CITY OF ALBUQUERQUE

April 5, 2019

RE: 1001 Pinatubo Place NW
Hydrology File: J09D018A

REVISIONS	CITY OF ALBUQUERQUE
	DRAINAGE
	DRAIN LINE THROUGH CURB
DMC: 2235	DECEMBER 2017

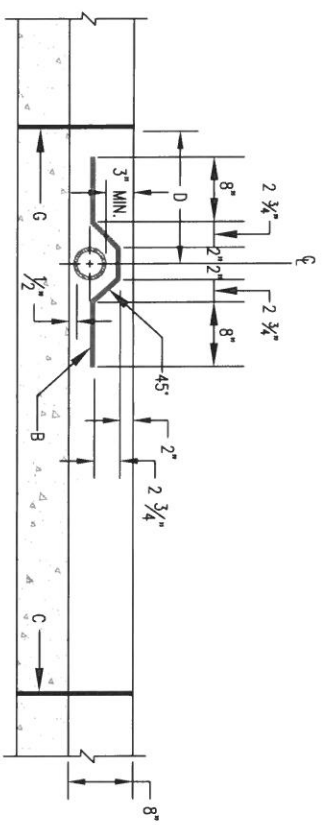
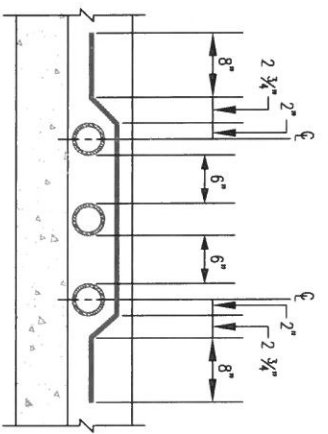
Based upon our phone conversation on 04/05/2019, you are granted a variance from the City of Albuquerque Detail #2235 and are allowed to core the curb instead of providing the rebar per the detail.
